Martin Nugent
01254 828060
D3/12/0723

Drafted 2 October 2012

Planning Applications, Ribble Valley District
3/12/0723 site of former stable block, Trapp Lane, Simonstone

PROPOSED GARAGES

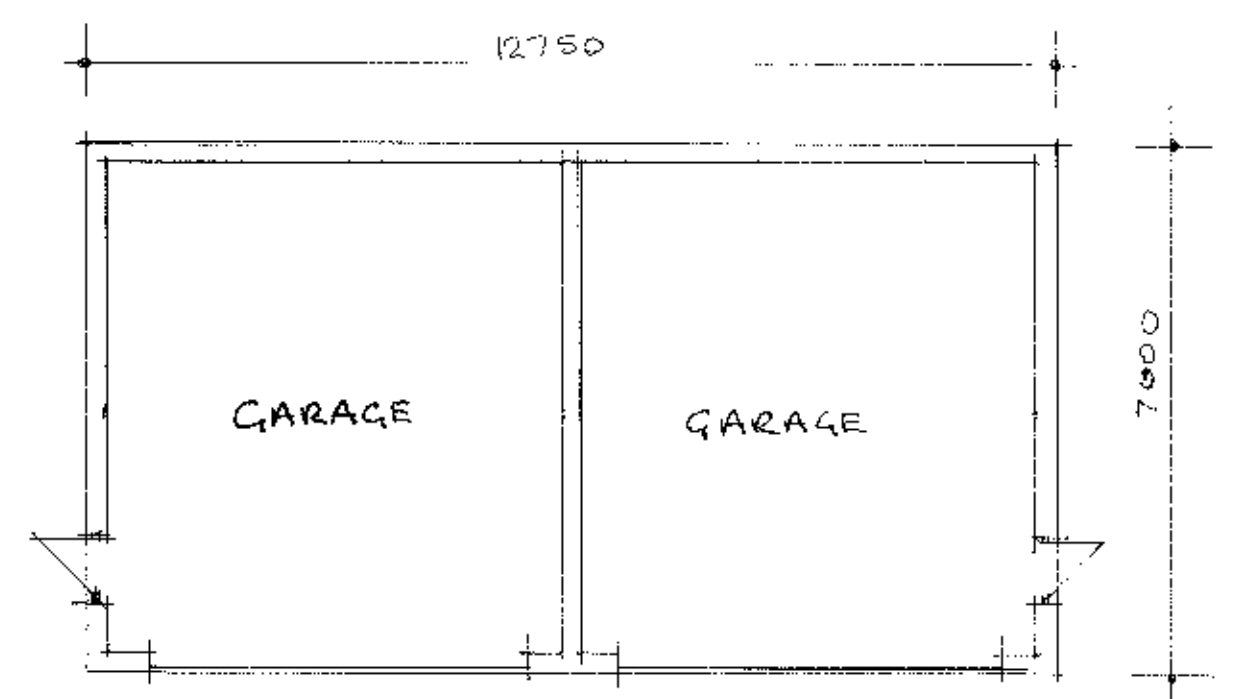
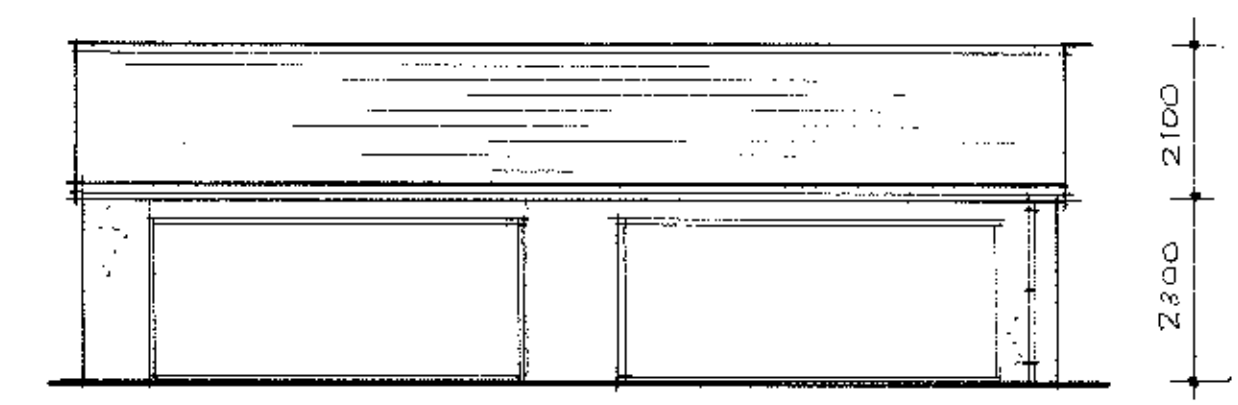
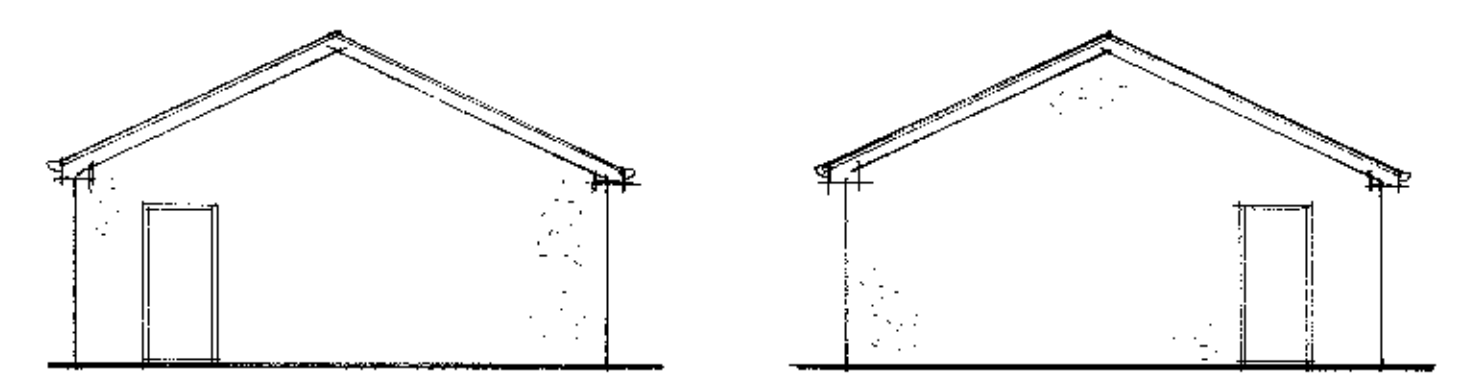
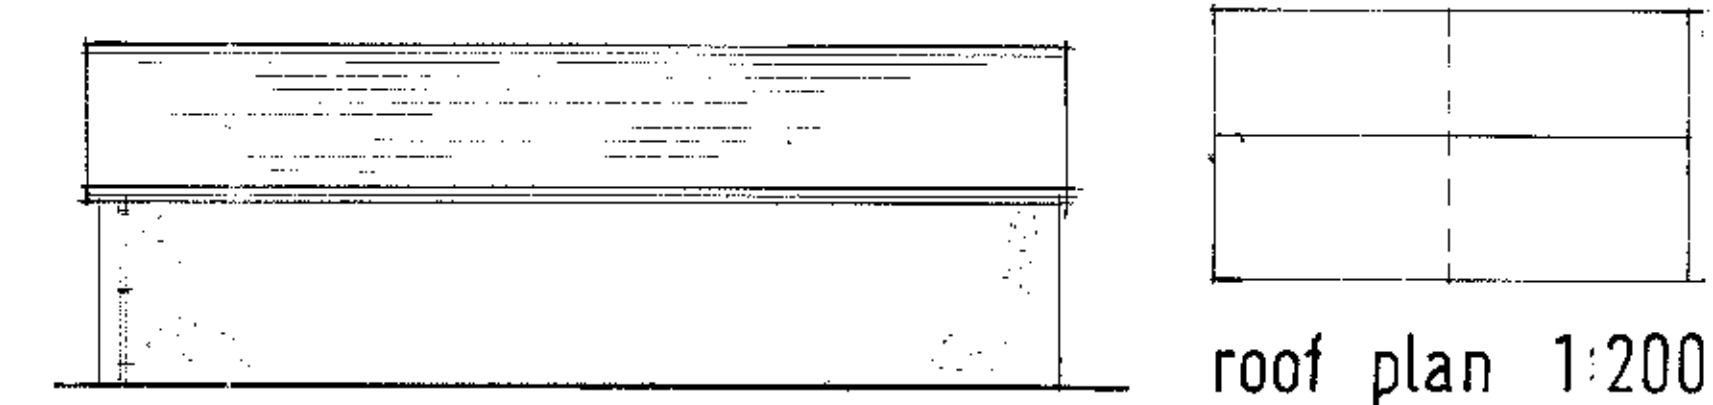
There is adequate off street parking provided for the two four-bedroom properties. The eight car parking spaces include a block of two double garages. In order to retain the intended use of these amenities in perpetuity, I have included an appropriate Condition.

1. A Condition to be attached to any successful application that seeks to retain the use of the garage for its intended purpose in perpetuity and to prohibit any future conversion to residential living space.
